**From:** [REDACTED]  
**To:** [REDACTED]  
**Subject:** FW: FW: Deposit Our ref: 24/00037/F  
**Date:** 24 January 2024 11:34:12  
**Attachments:** [REDACTED]

NORTH ELEVATION PROPOSED. 1/100

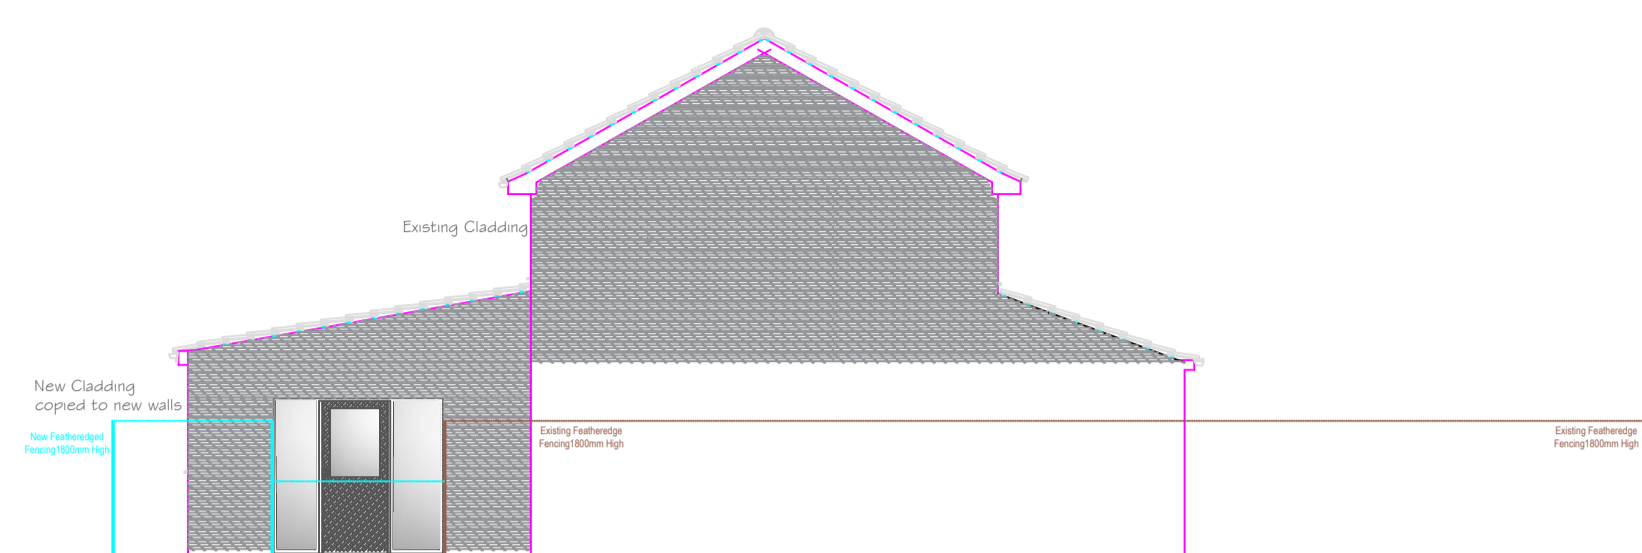
I am missing the existing and proposed north elevation. I also need a separate elevation showing the fence details. Confirm the exact position and extent of the new fence on the proposed site plan.

GROUND FLOOR PLAN AS PROPOSED  
1/50

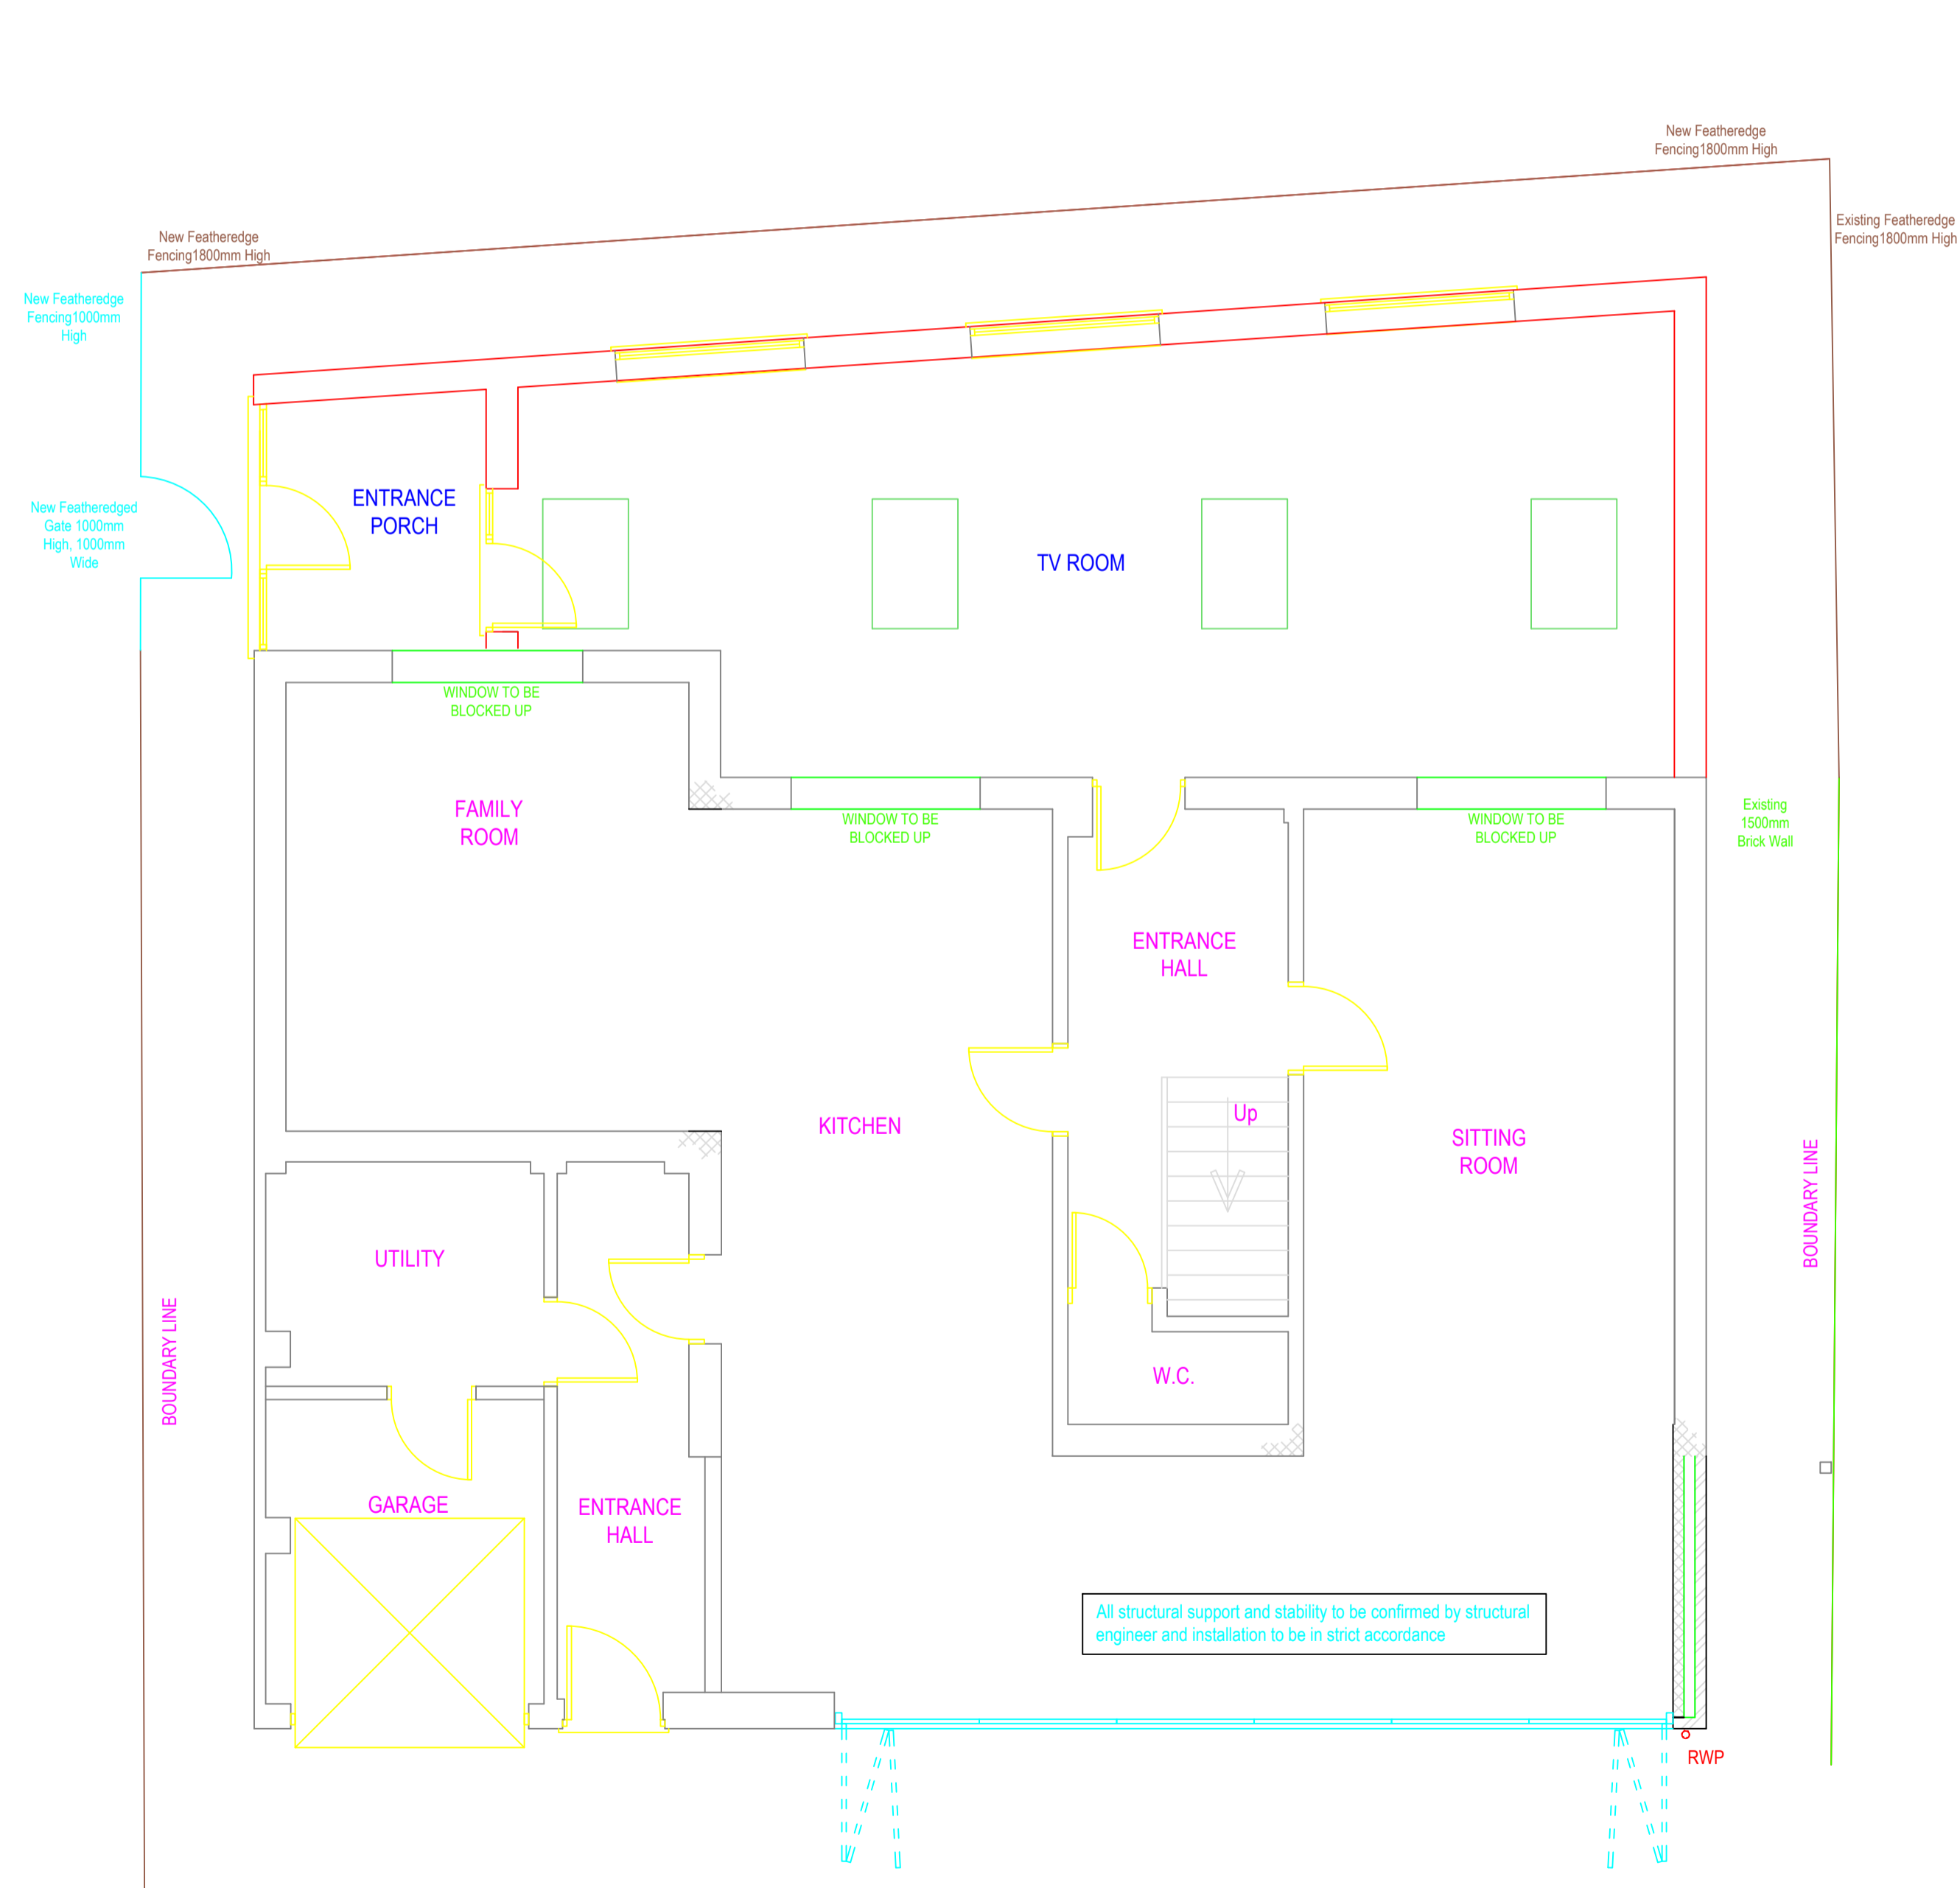
Yes, you have shown the floor levels on the drawings, I just need confirmation that the site levels are to remain as existing.

Also you need to confirm that the site levels will remain as existing and that the new floor level will match the existing floor level.

Good Morning,  
Floor levels remain the same throughout the proposed extension and building.

The main drawings issued do show on them that all floor levels remain the same and this is shown in Red Text with a dotted line.

SITE LOCATION PLAN  
1/1250

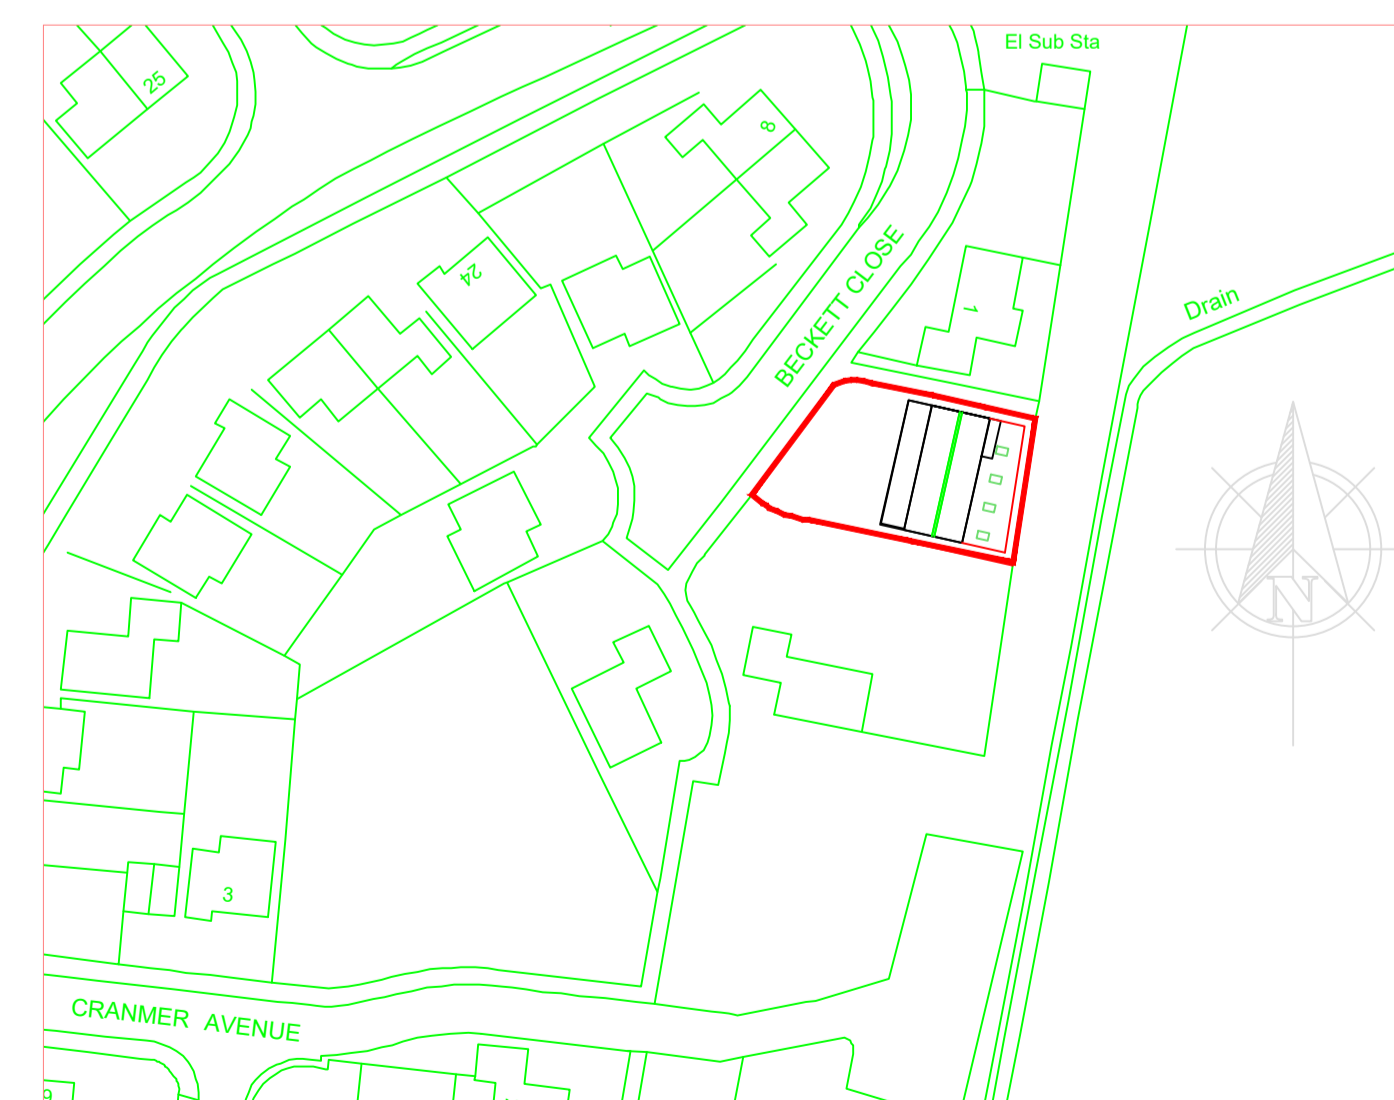
My apologies, I did forget to ask you for a block plan to a scale of 1:500 or 1:200

showing the dwelling with the extension.

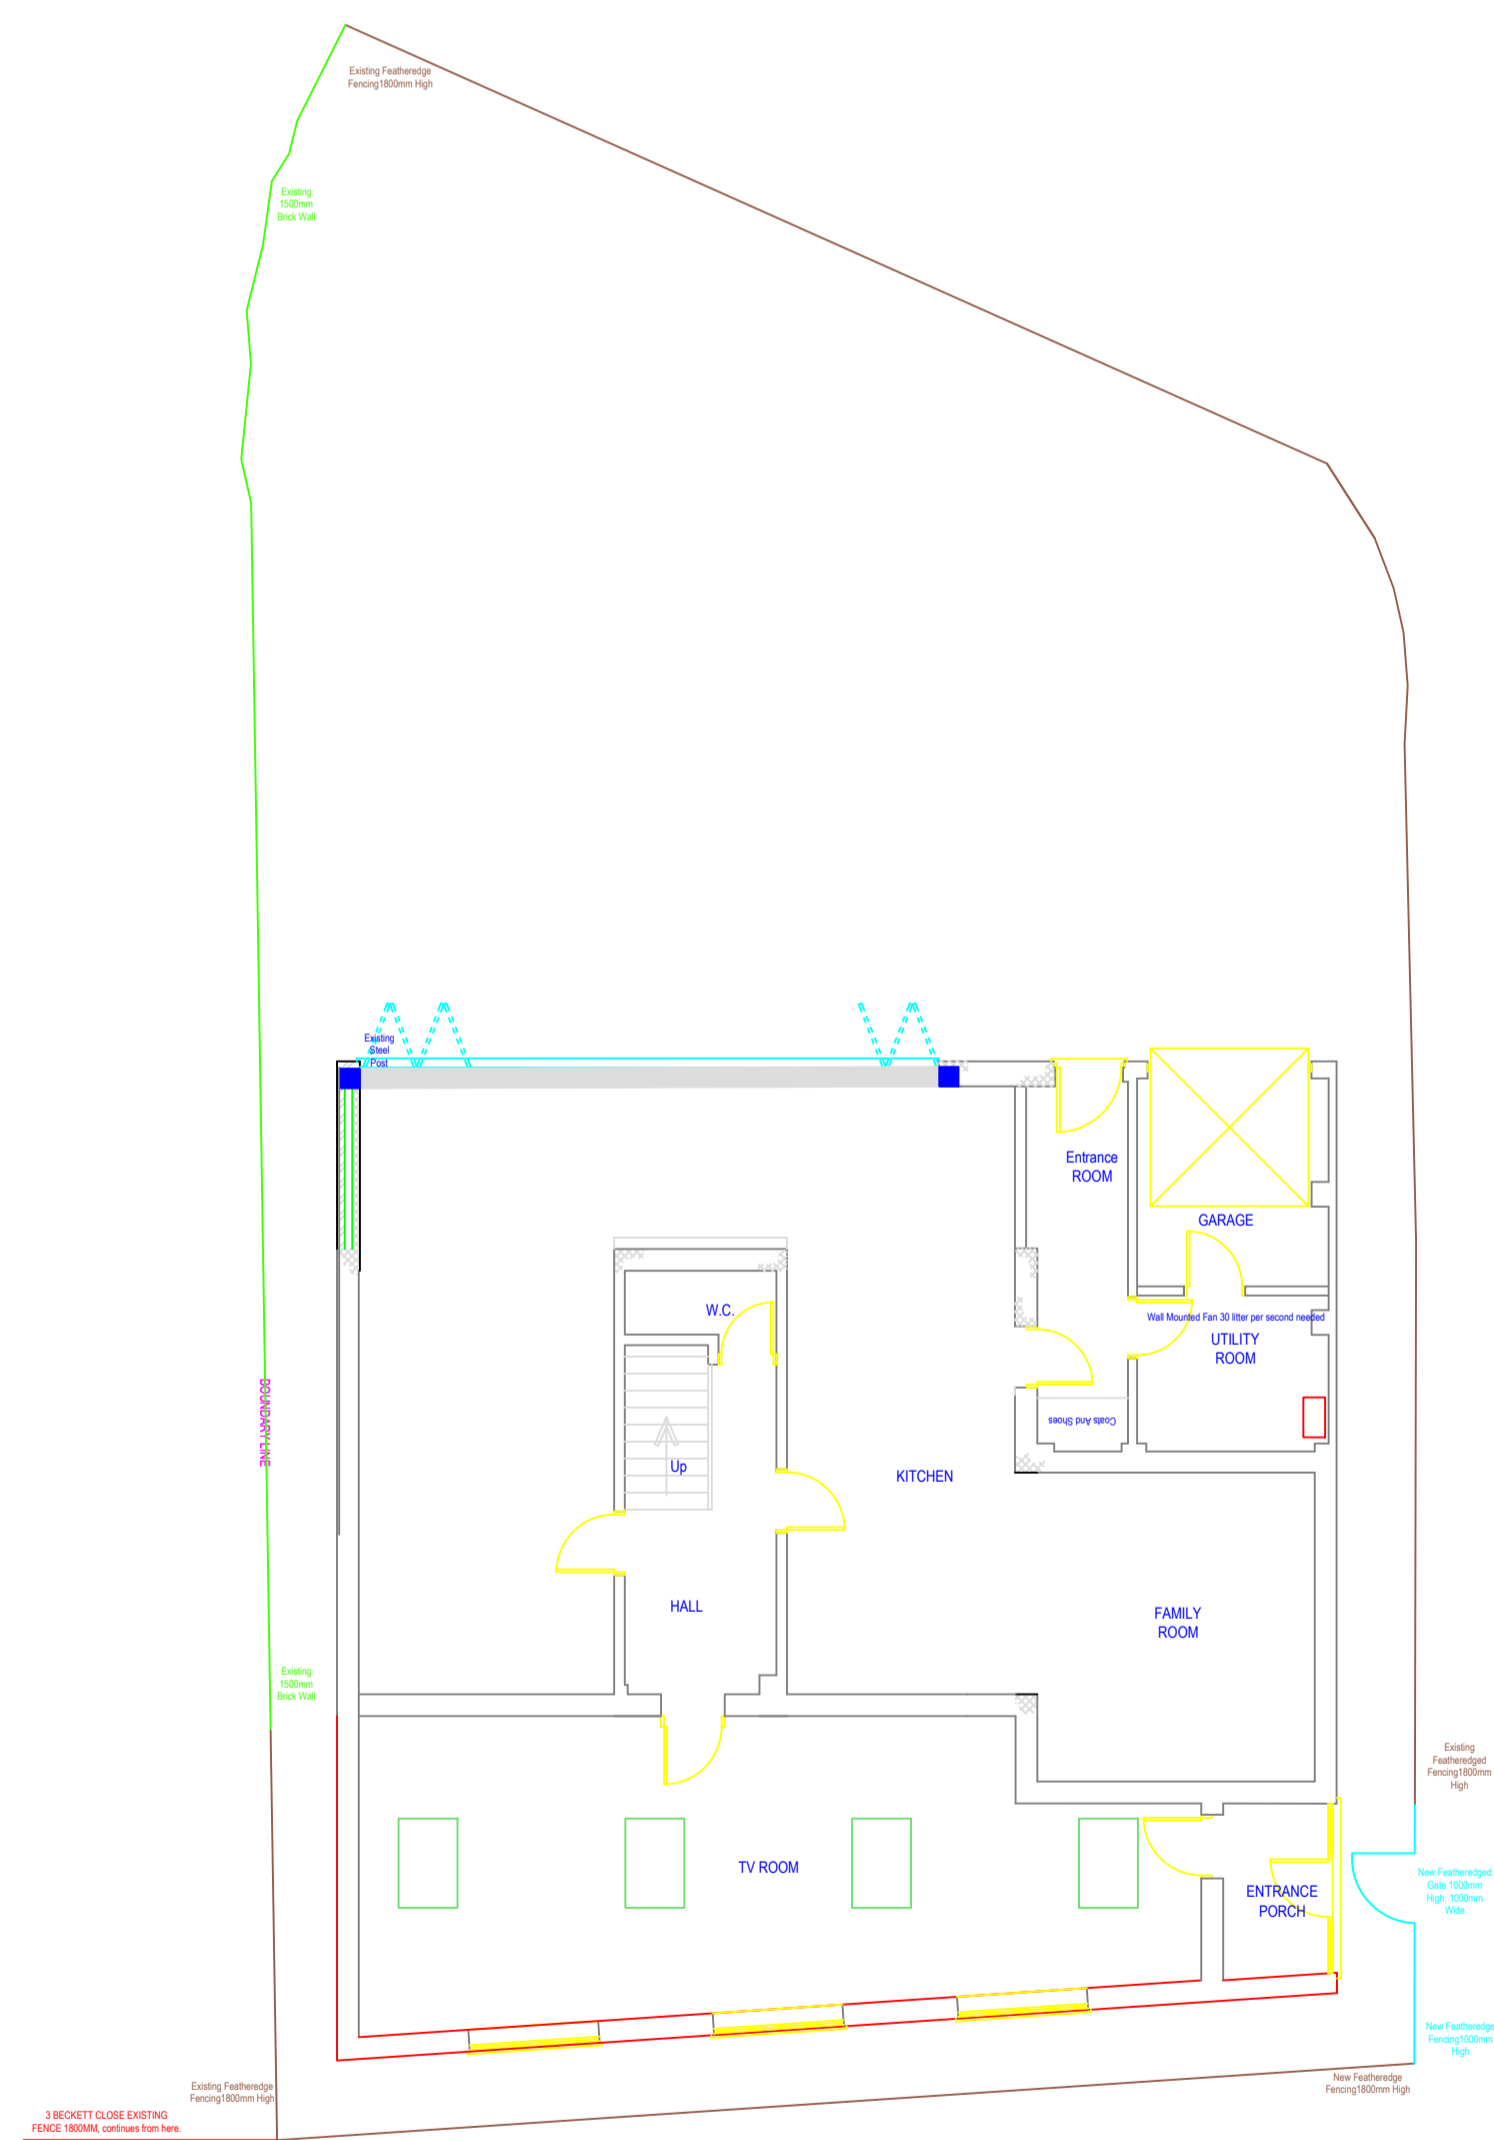
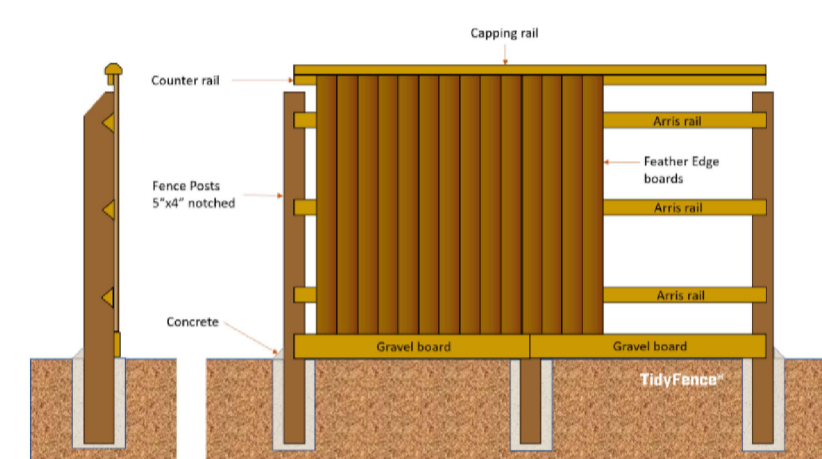
I do still require a separate scaled elevation of the fence showing the details of the fence rather than the transparent view over the front elevation.

Please see attached the fence drawing showing existing and proposed additions.
